DRB Comments

PROJECT # 1002786

APPLICATION # 04-01635

RE: Gateway Park/SPBP

Elevations and Perspectives

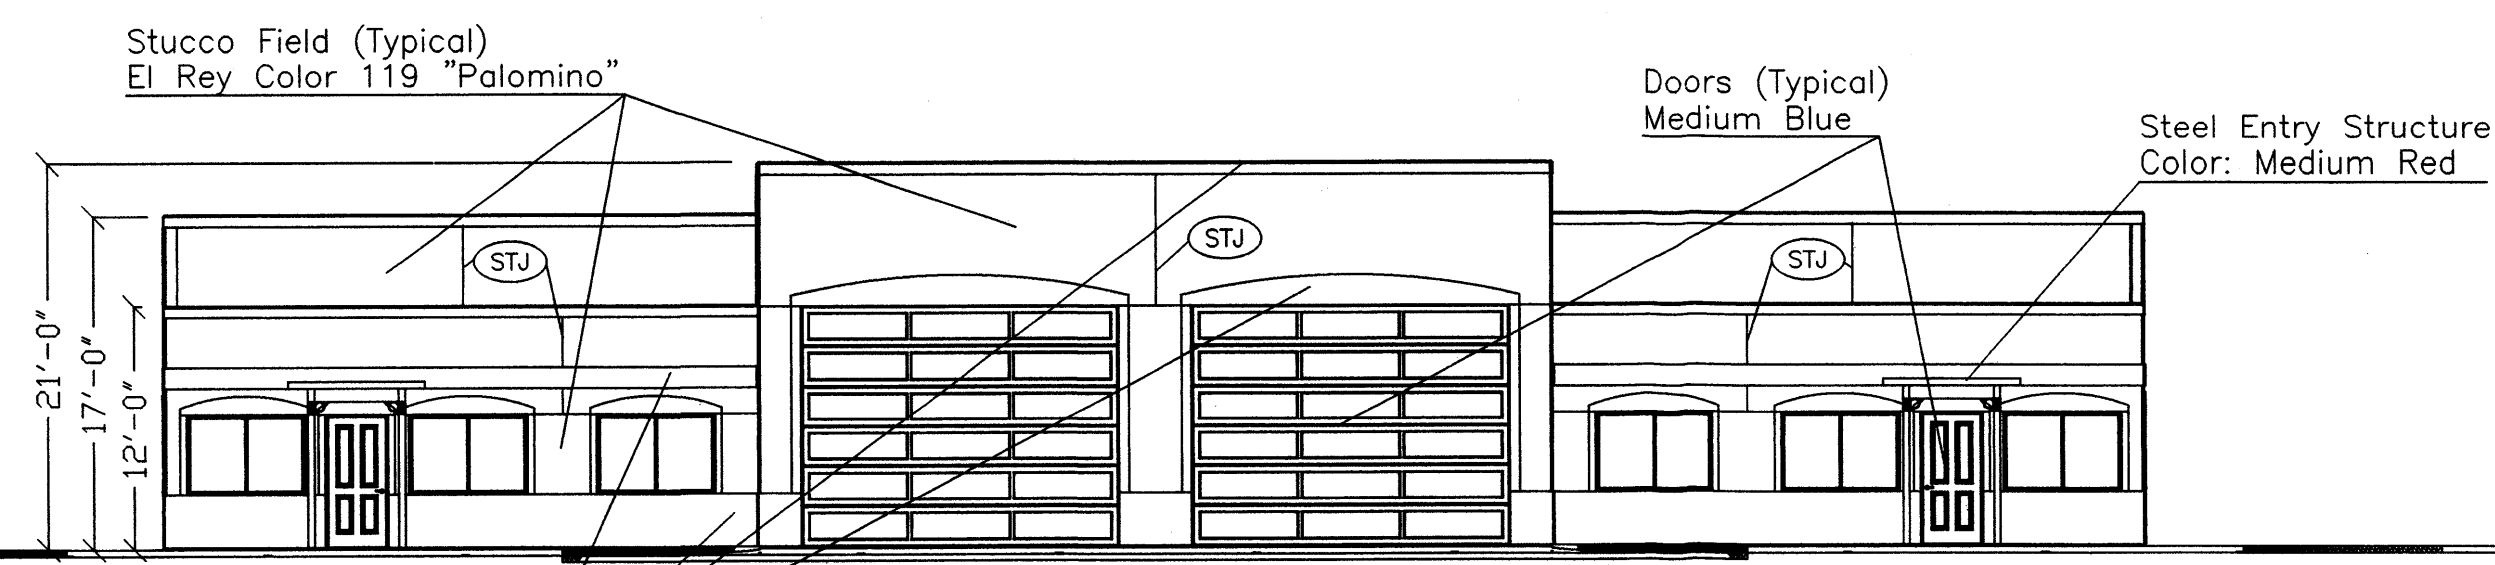
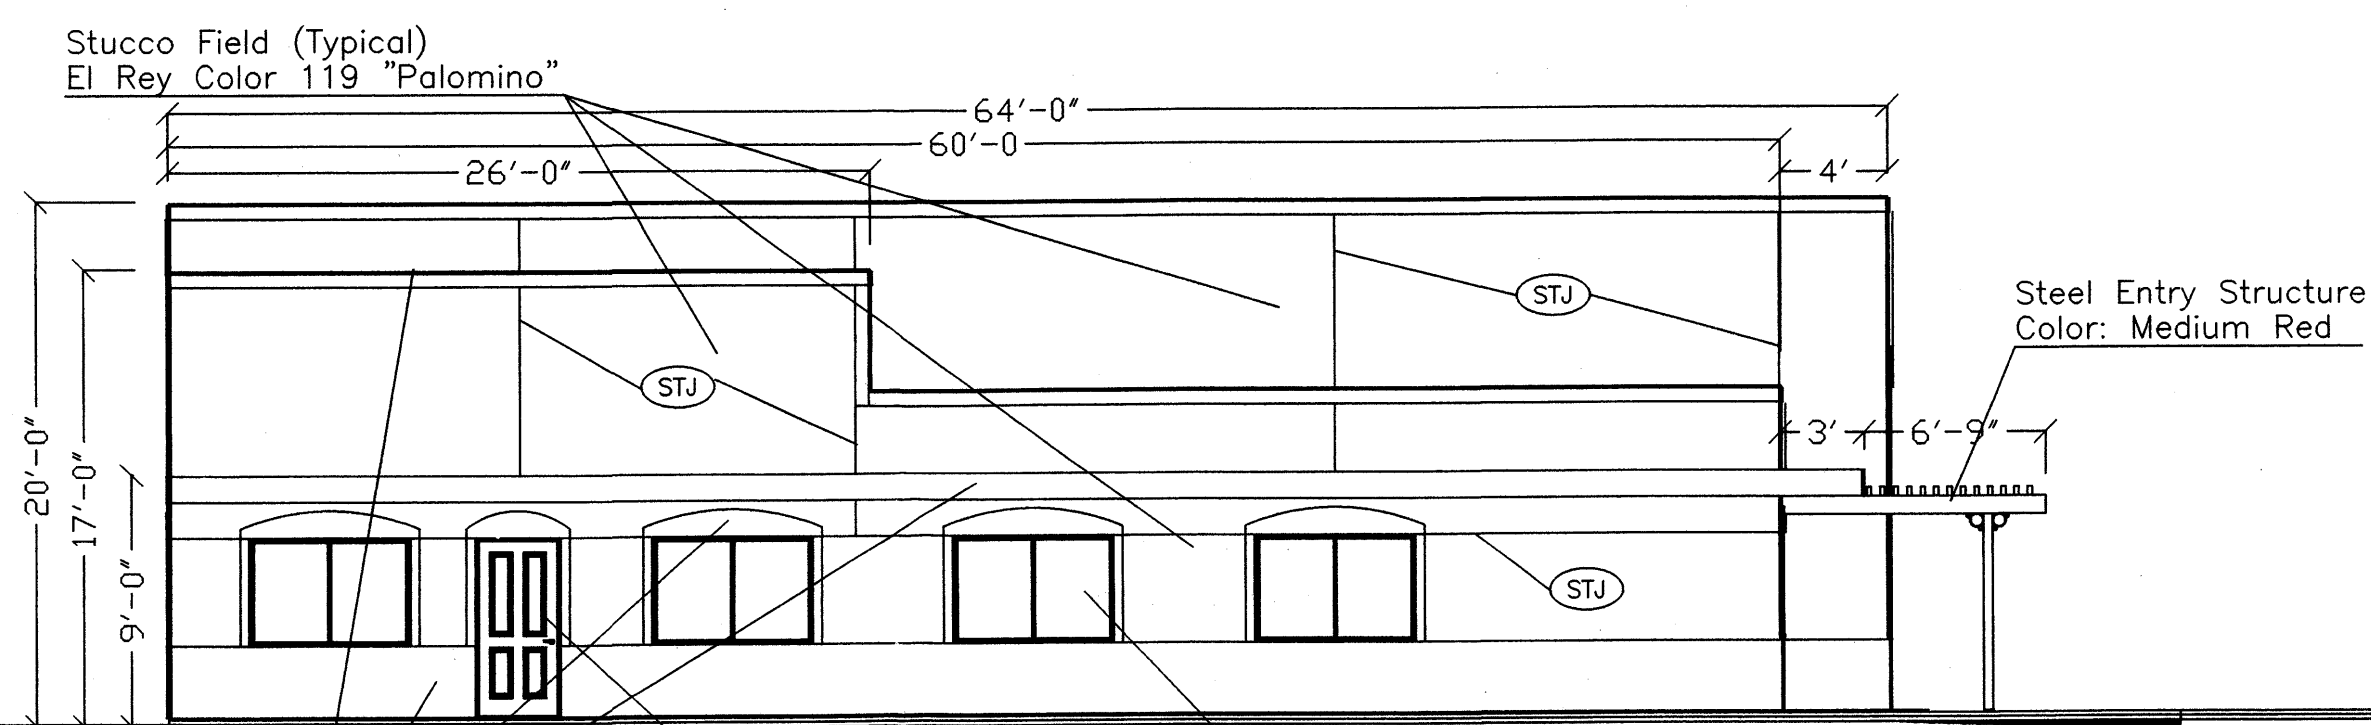
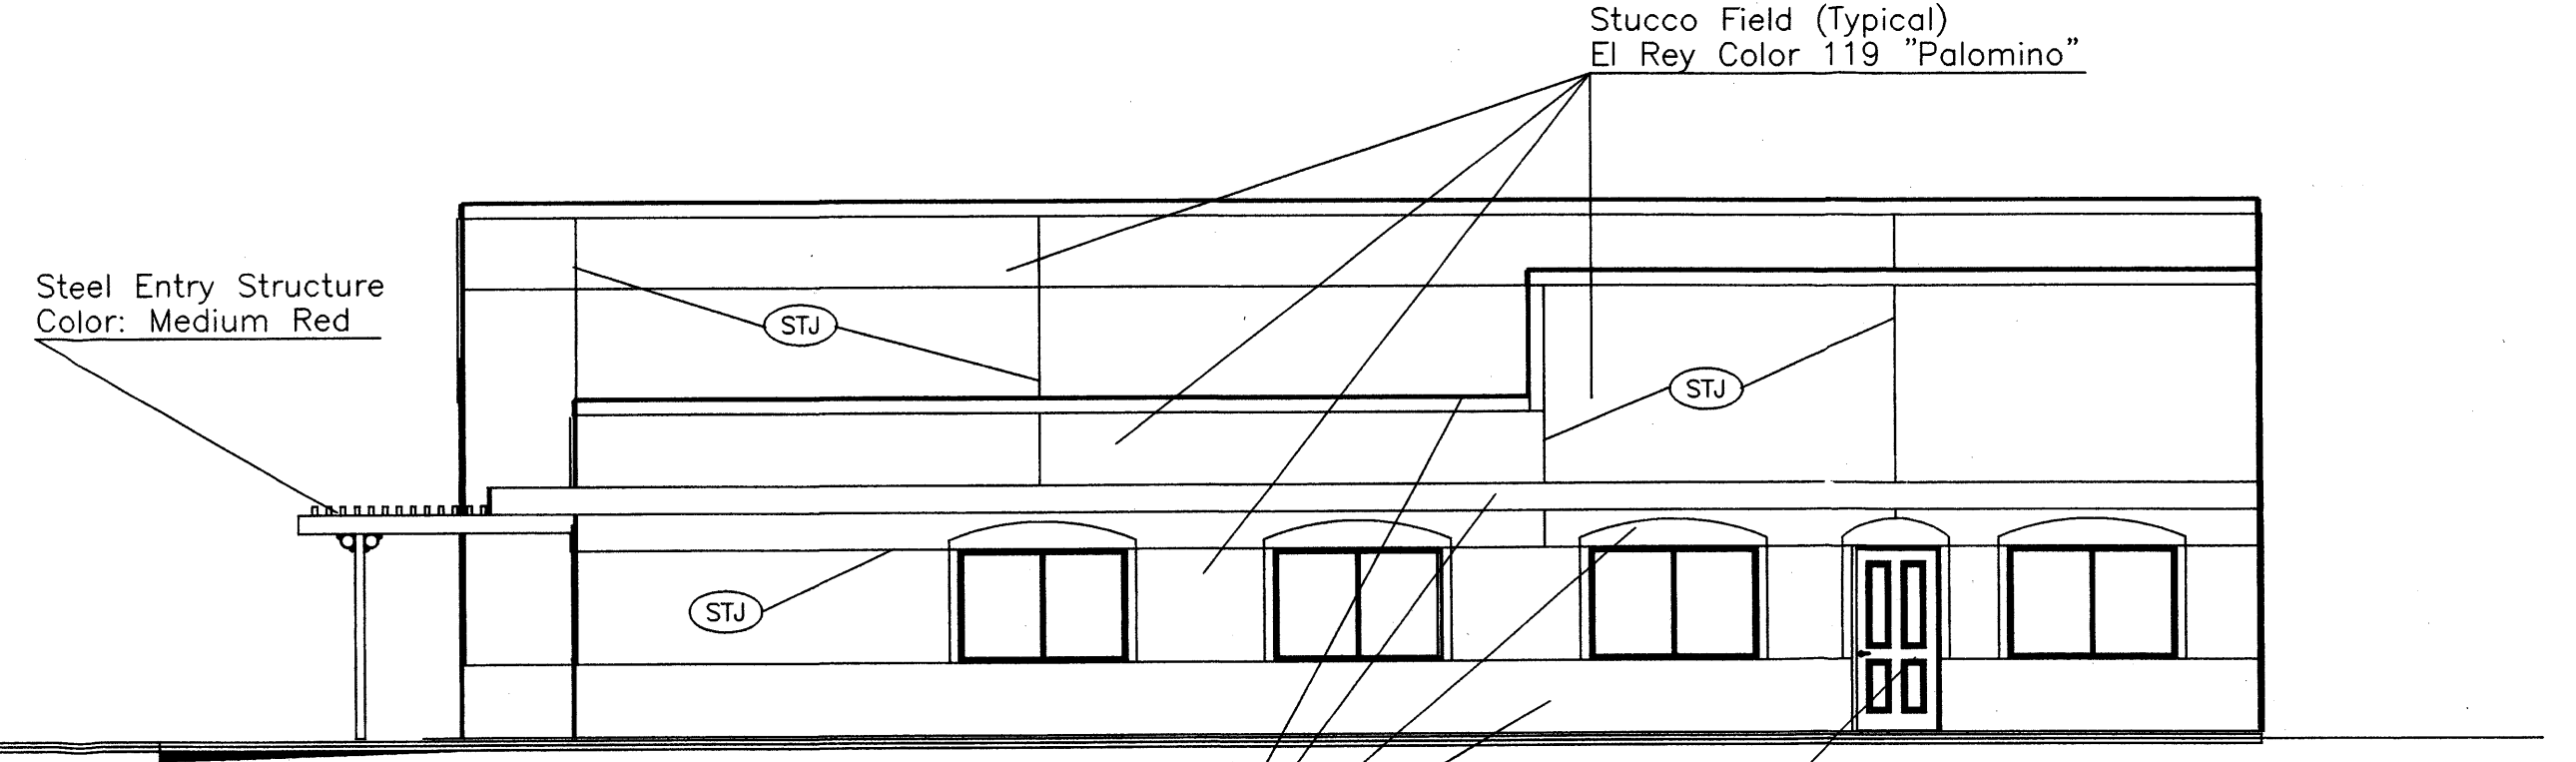
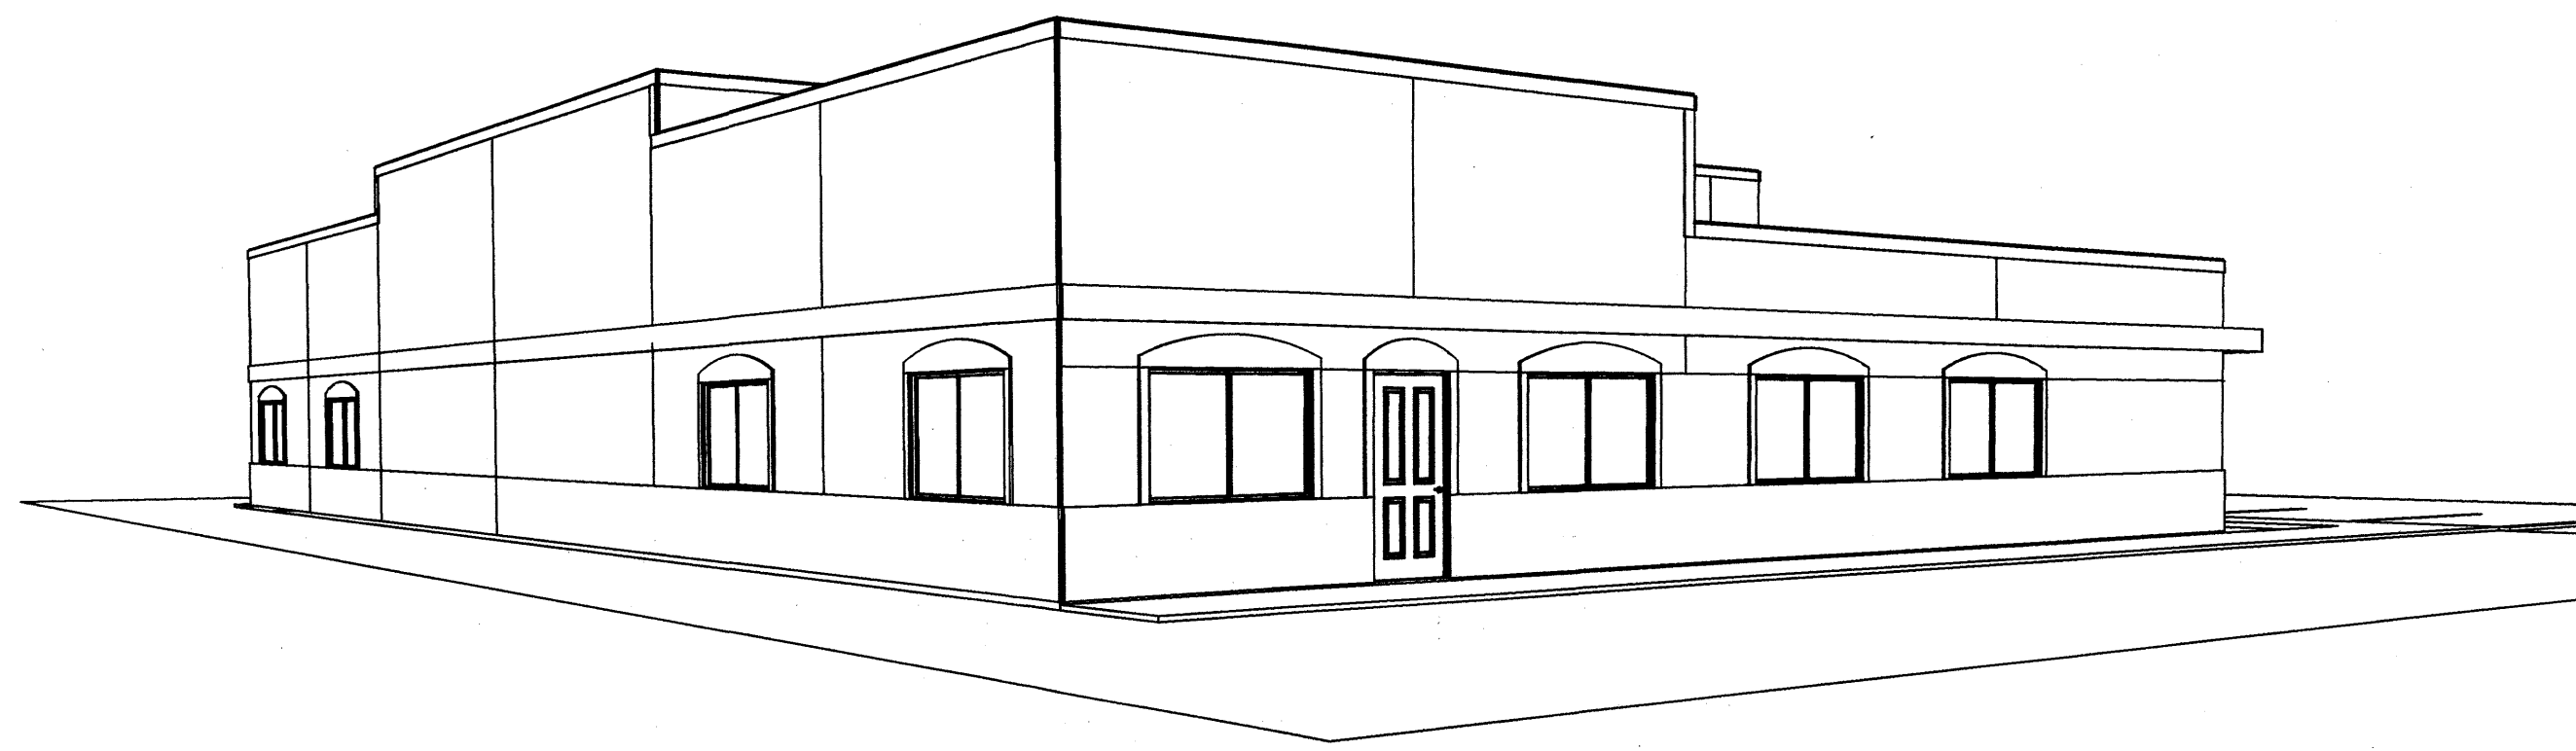
- ✓ 8. The Building Elevations sheet has no scale.

Site Development Plan - Buildg. Permit
Site Plan

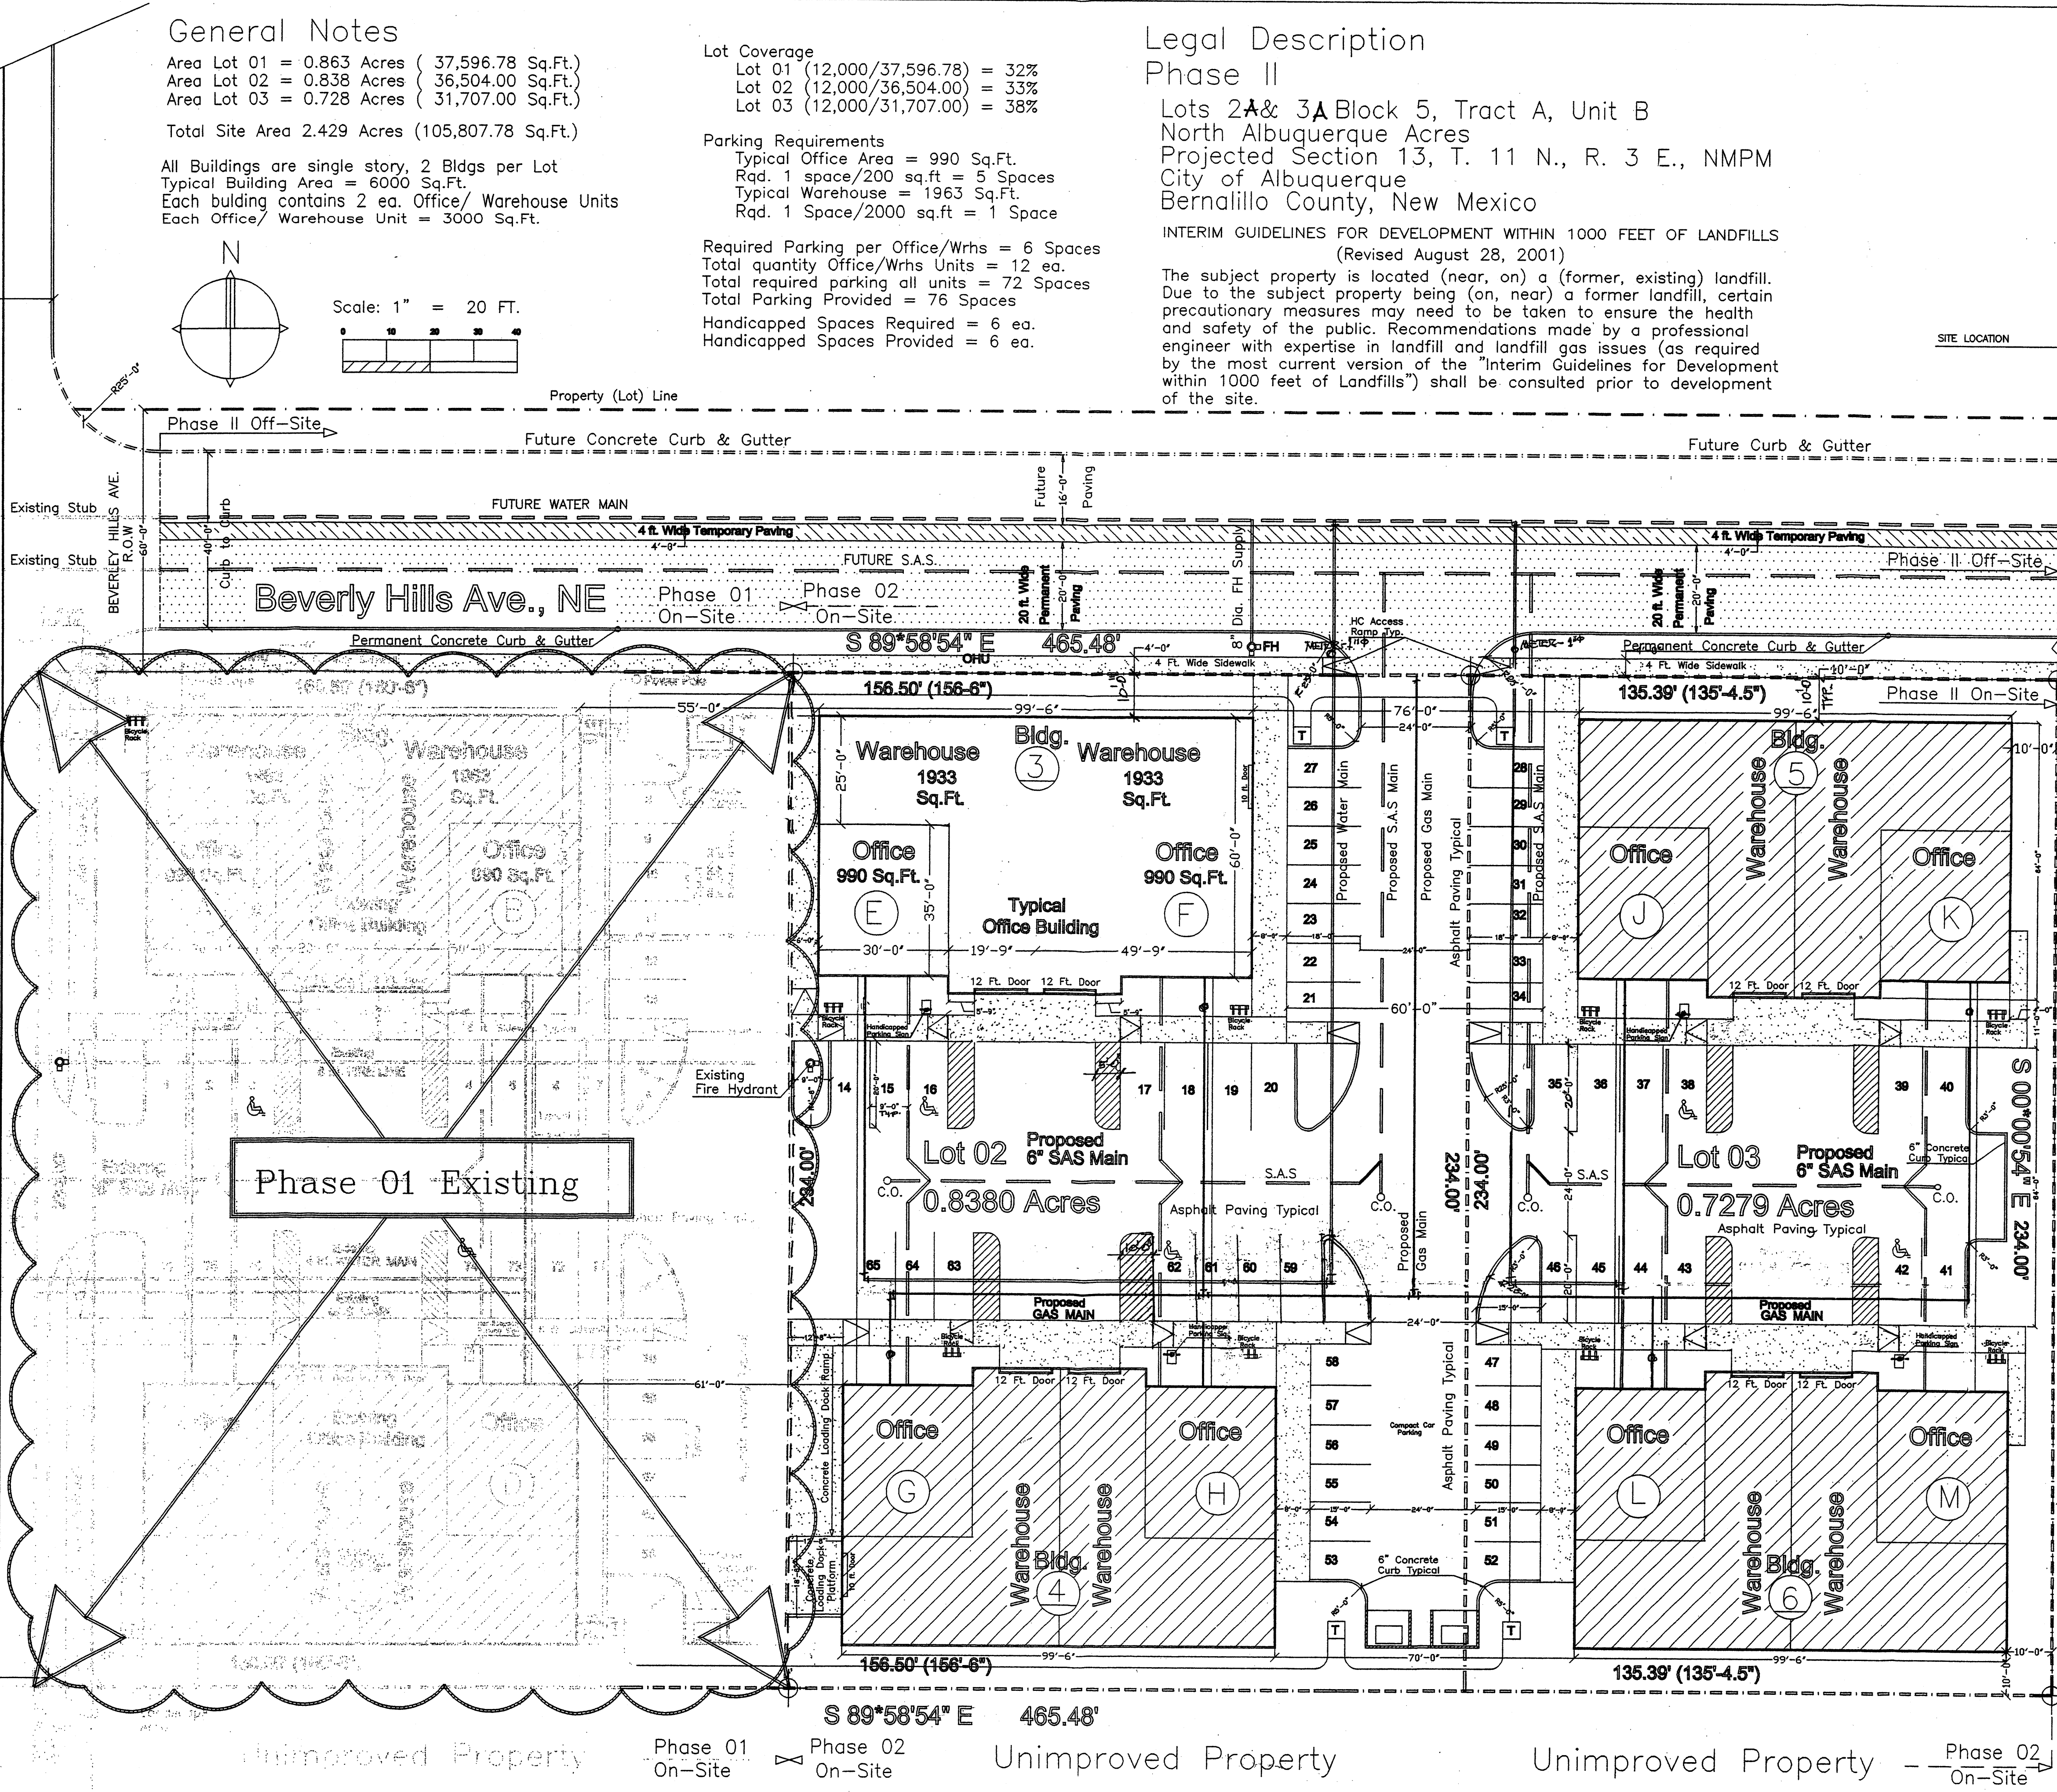
- ✓ 1. The site plan sheet should be titled Site Development Plan for Building Permit. "Development" should be spelled correctly.
- ✓ 2. The submittal is missing the written project summary required per the SPBP Checklist.

- ✓ 3. The property line for this property needs identification. The adjoining property's line is identified but not the one for this development.
- ✓ 4. Are any building mounted signs planned for this part of the development? Even building mounted signs must be shown & details as specified in the checklist provided.
